From: Planning
Sent: 07 January 2022 14:53
To: DC Support
Subject: FW: App Ref: 21/04275/OUT - Land north of Lords Farm - Sport England Ref: PA/22/SE/CL/60562

From: Bob Sharples <Bob.Sharples@sportengland.org>
Sent: 07 January 2022 14:08
To: Caroline Ford <Caroline.Ford@Cherwell-DC.gov.uk>; Planning <Planning@Cherwell-DC.gov.uk>
Cc: Thomas Darlington <Thomas.Darlington@Cherwell-DC.gov.uk>
Subject: App Ref: 21/04275/OUT - Land north of Lords Farm - Sport England Ref: PA/22/SE/CL/60562

Development Framework Plan

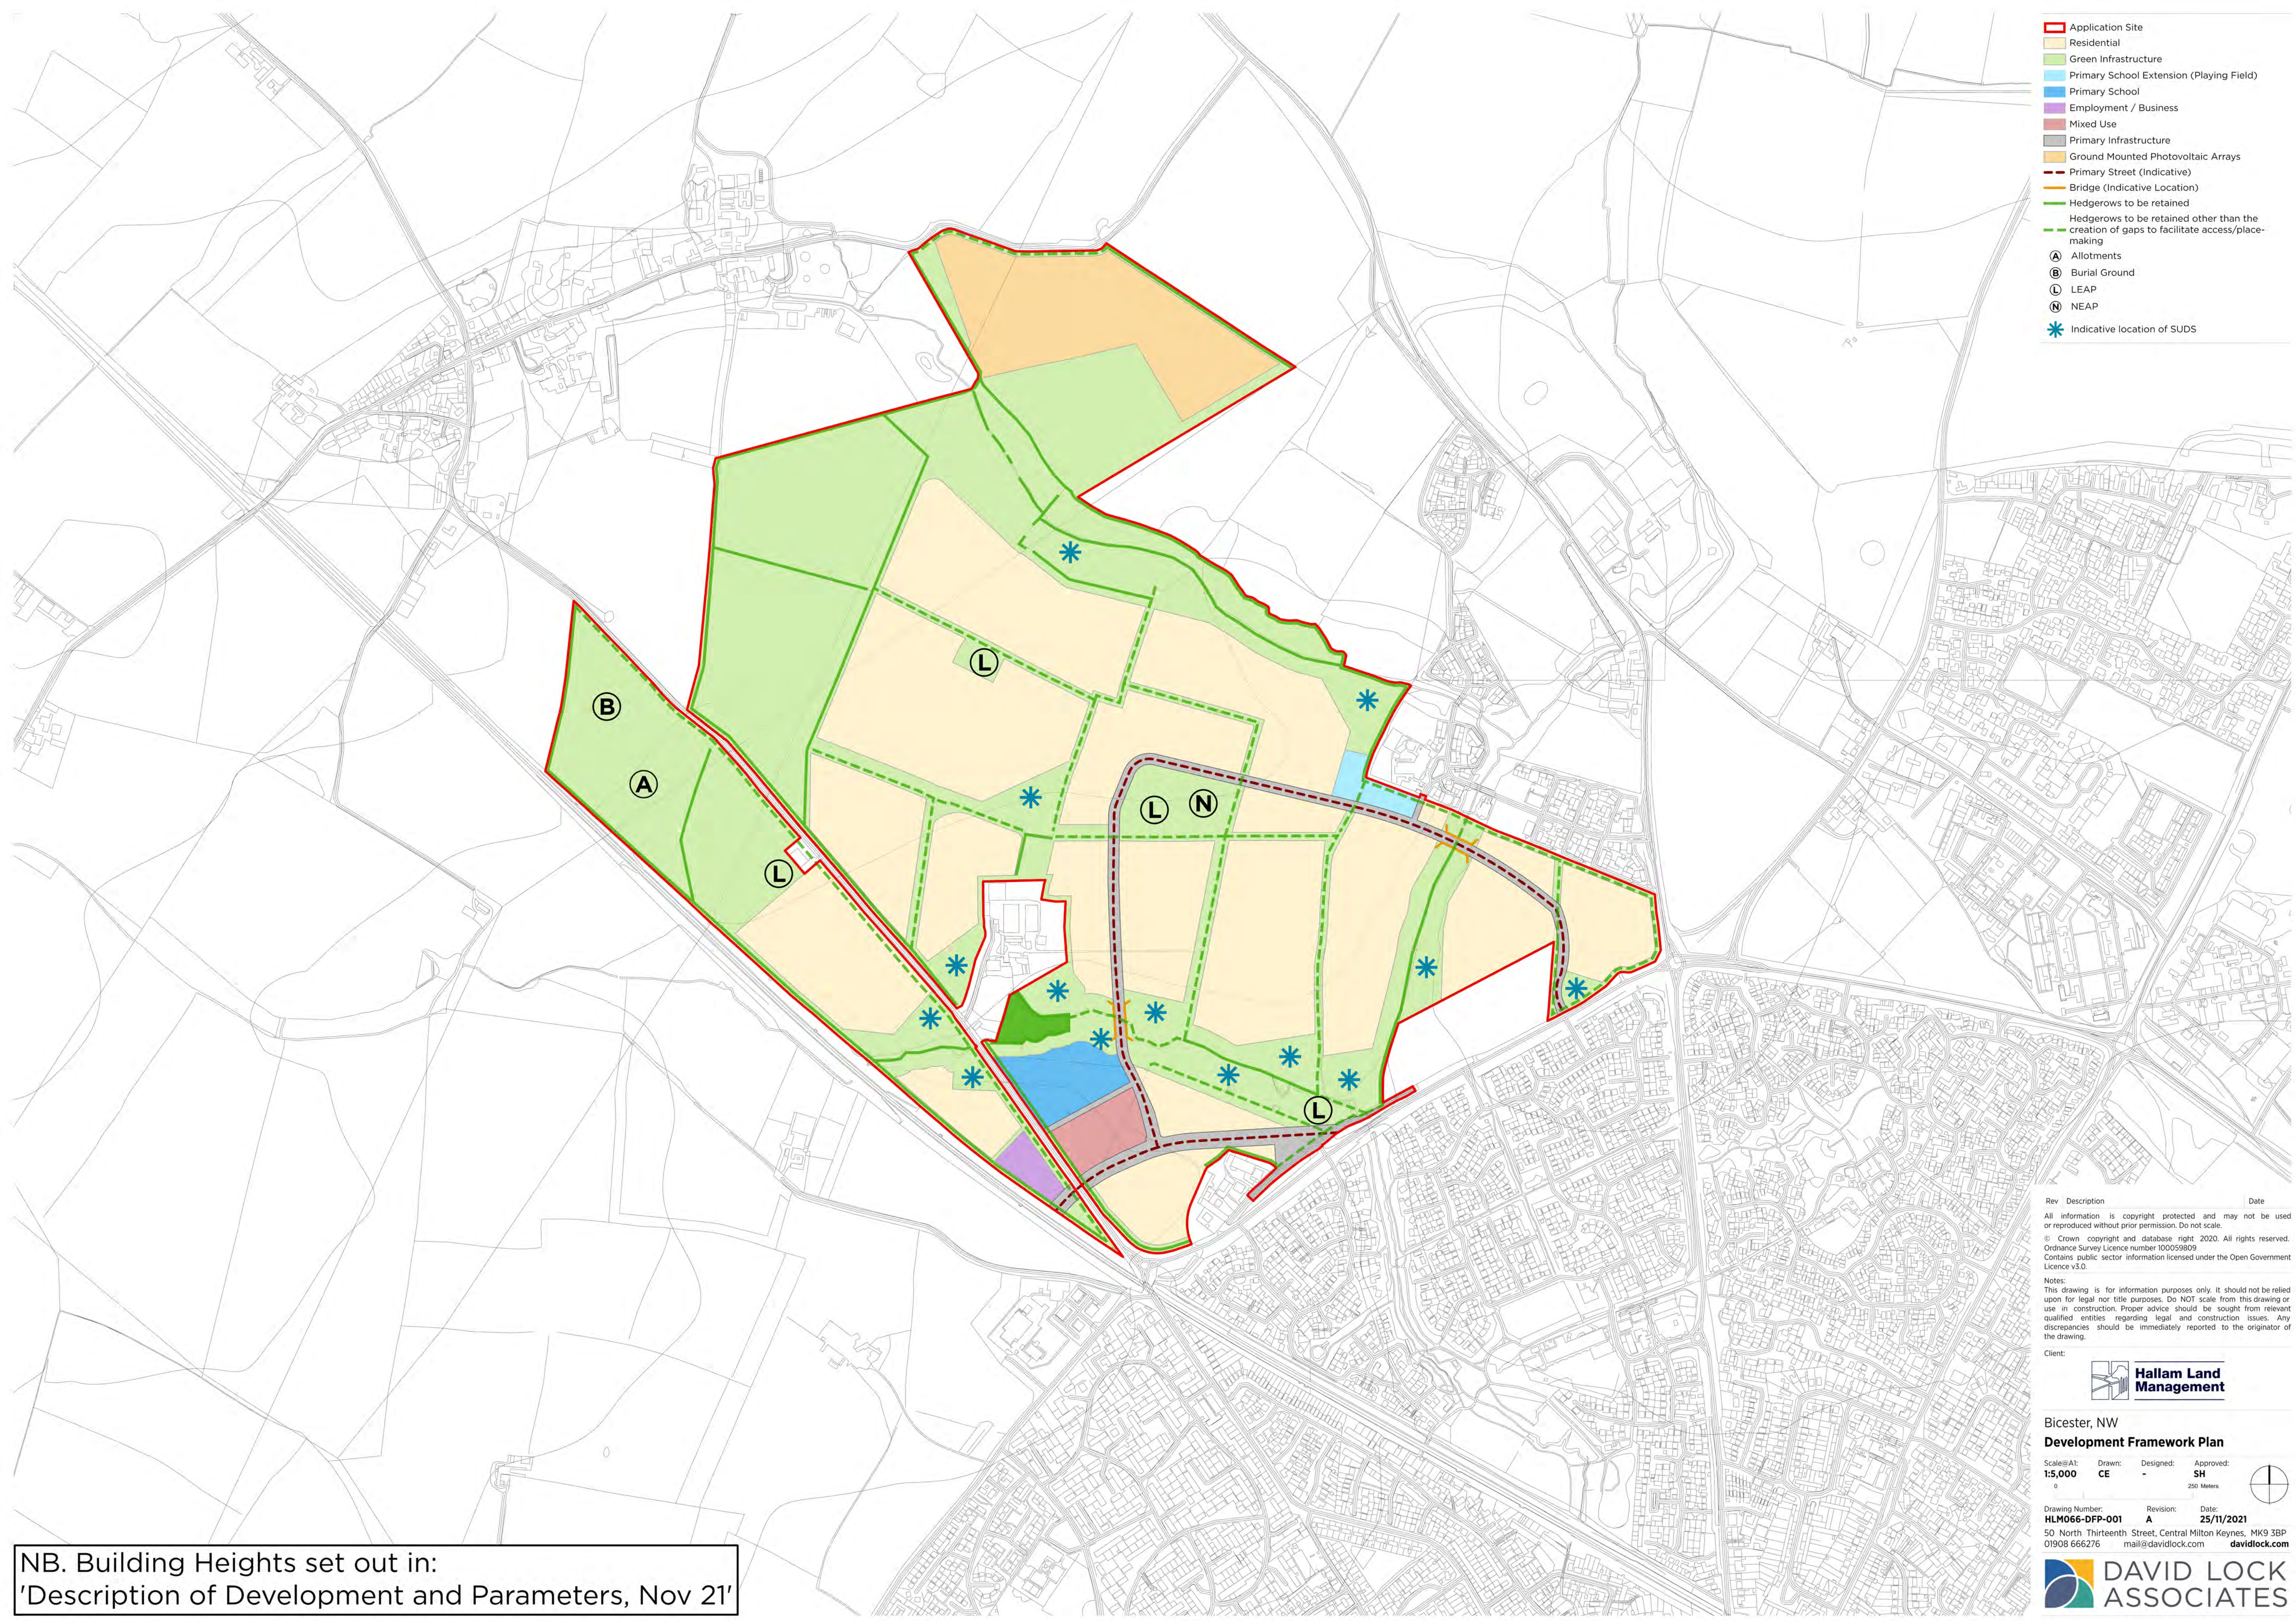
1. The planning application refers to formal playing fields, but I can only see one playing pitch. Can it be confirmed that there is more than one formal playing field? I would point out the at the formal playing field has a football pitch shown which is very tightly constrained and we would not be supportive without more details. We would also like understand why only football is provided for:
2. The following is taken from the Design and Access statement:
It is not anticipated that the application site will be required to provide the pitches implied in the Council's open space standards – although the Development Plan and description of development provides the flexibility to do so.
